**DRAINAGE LETTER FOR ACADEMY GATEWAY SUBDIVISION FILING NO. 1 –
LOT 1 – PROPOSED 7-ELEVEN**

October 30, 2017

**Re: Lot 1 – Academy Gateway Subdivision Filing No. 1
Drainage Compliance Letter**

**C2.2**  
SHEET 5 OF 16

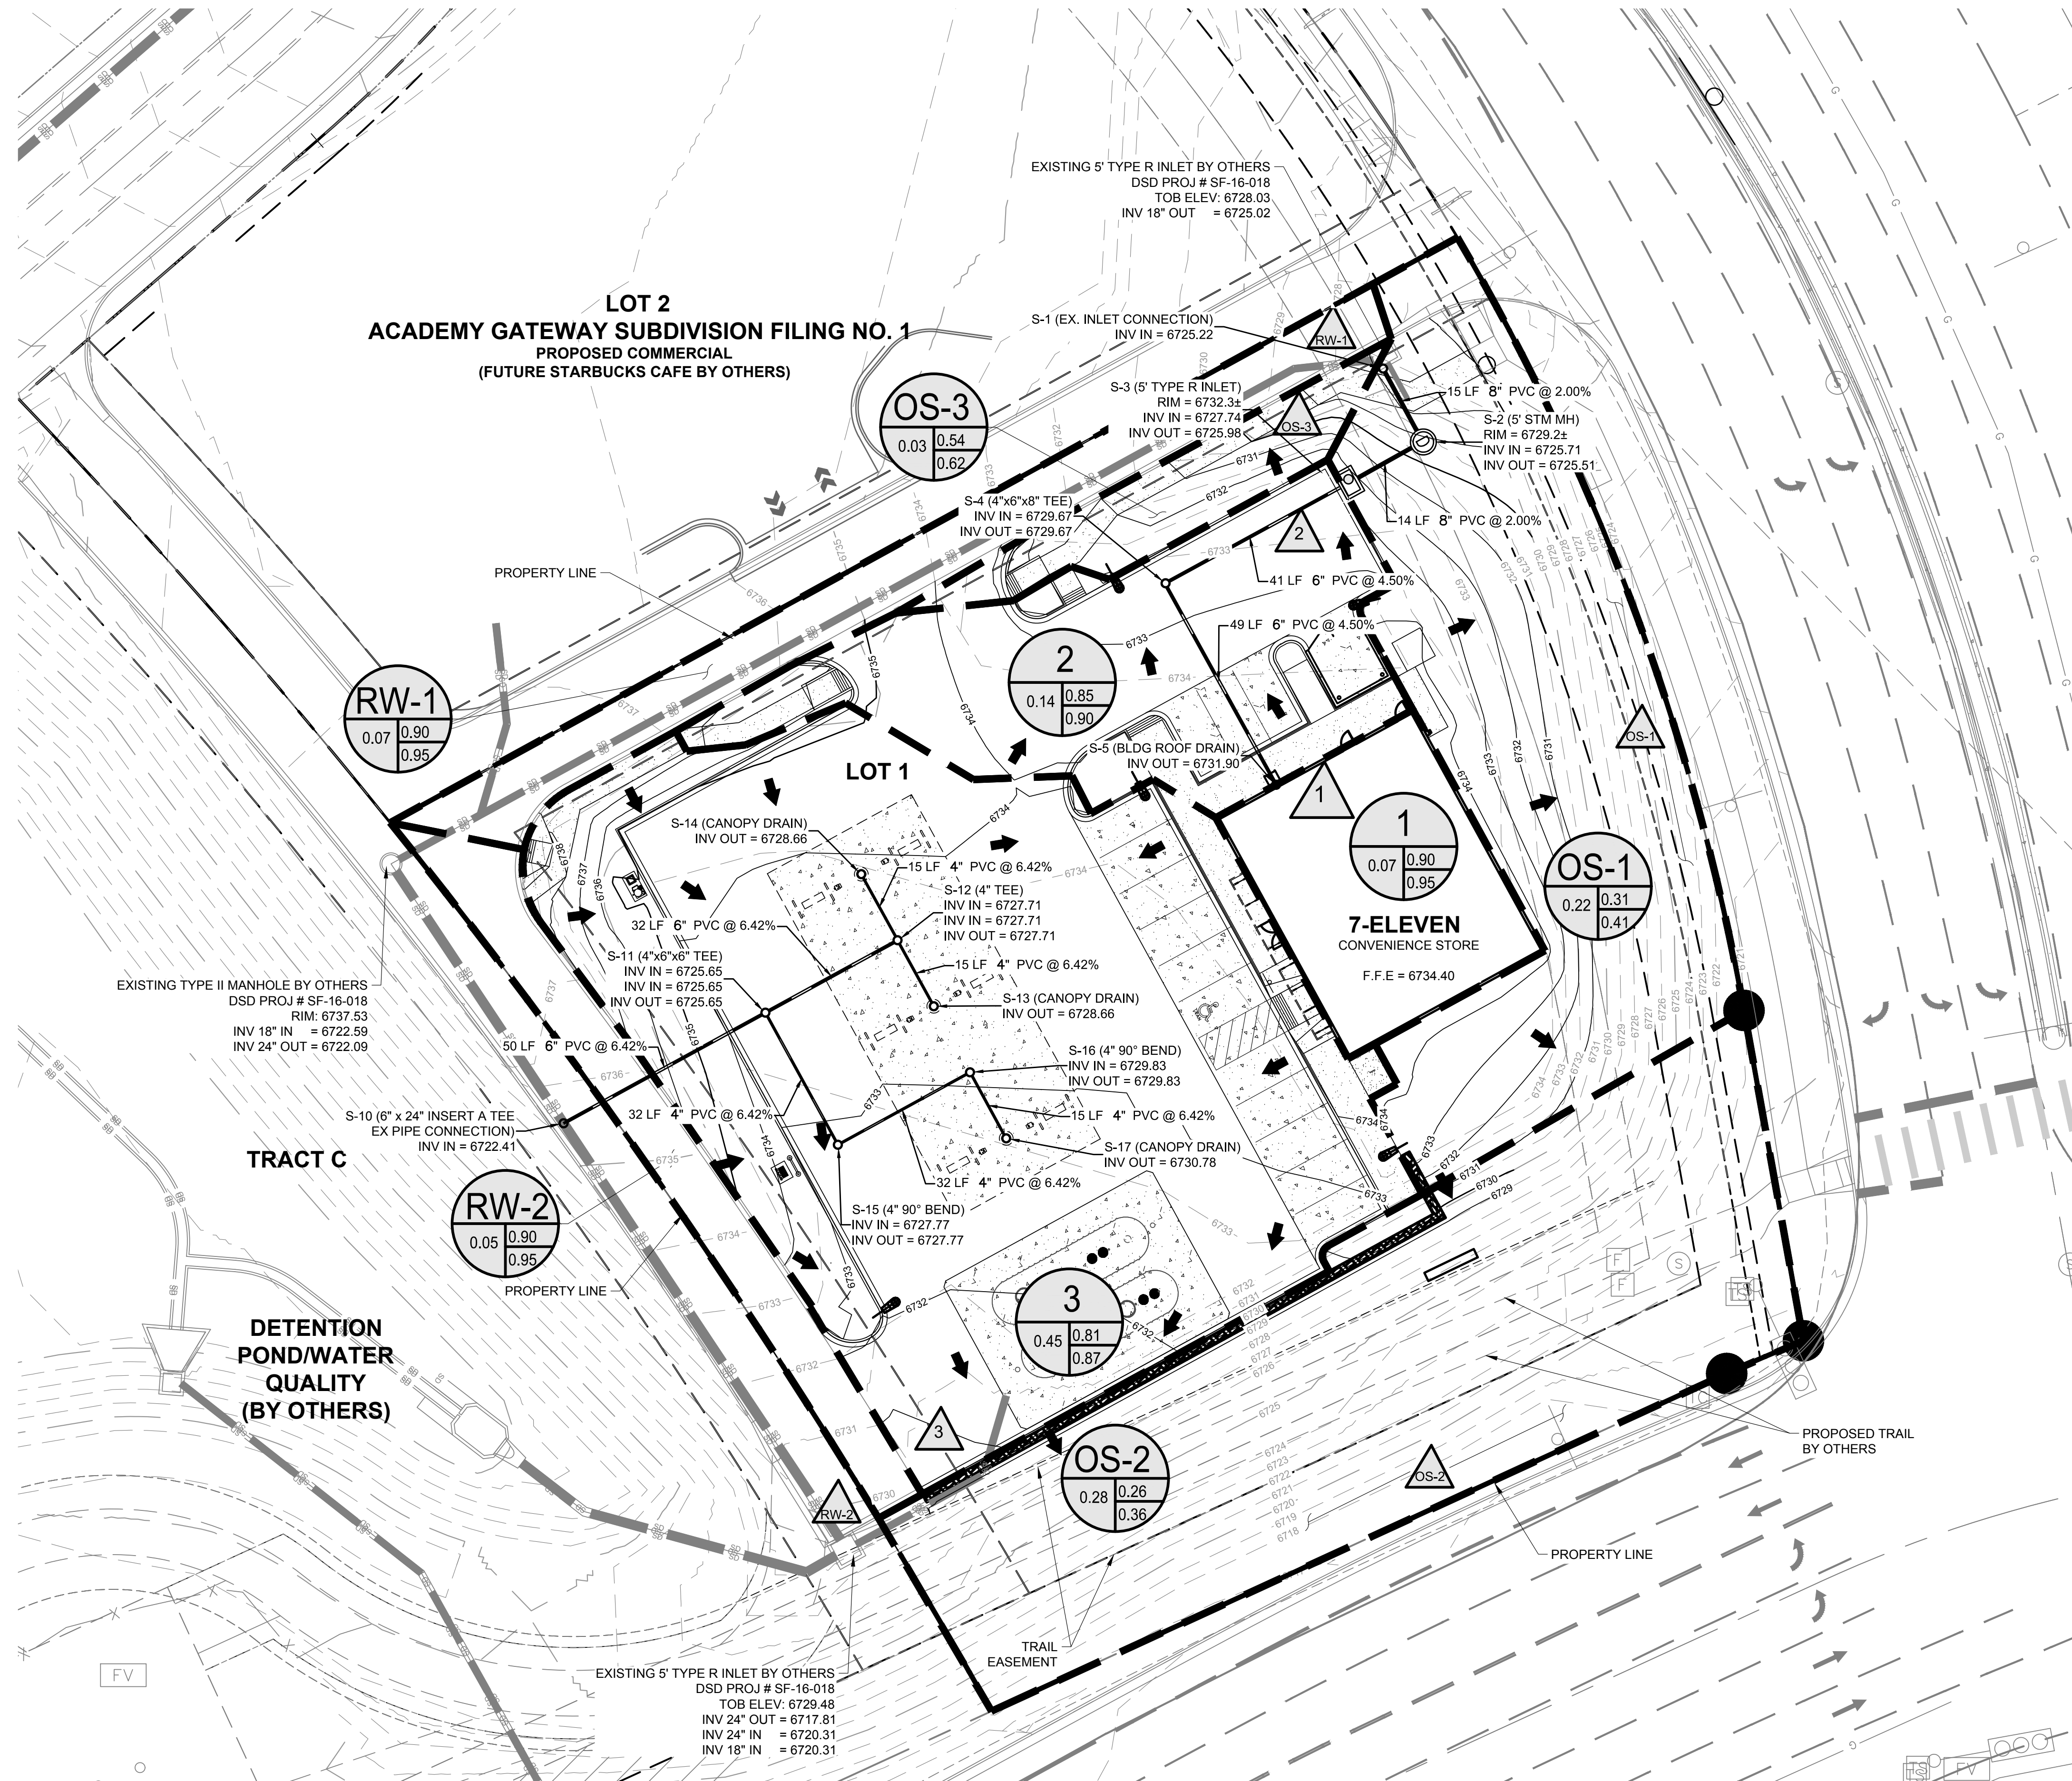
Add discussion on ECM Section I.7.2.A (four-step process) and I.7.2.D (page I-29, specialized BMPs for high risk sites). Specifically address boxes 6-9 on page I-28 and I-30, including how the subdivision WQCV pond or other onsite BMP(s) will meet the requirements. (Staff has repeatedly notified the Academy Gateway developer that the pond will be permanent unless individual sites provide their own WQCV BMPs.)
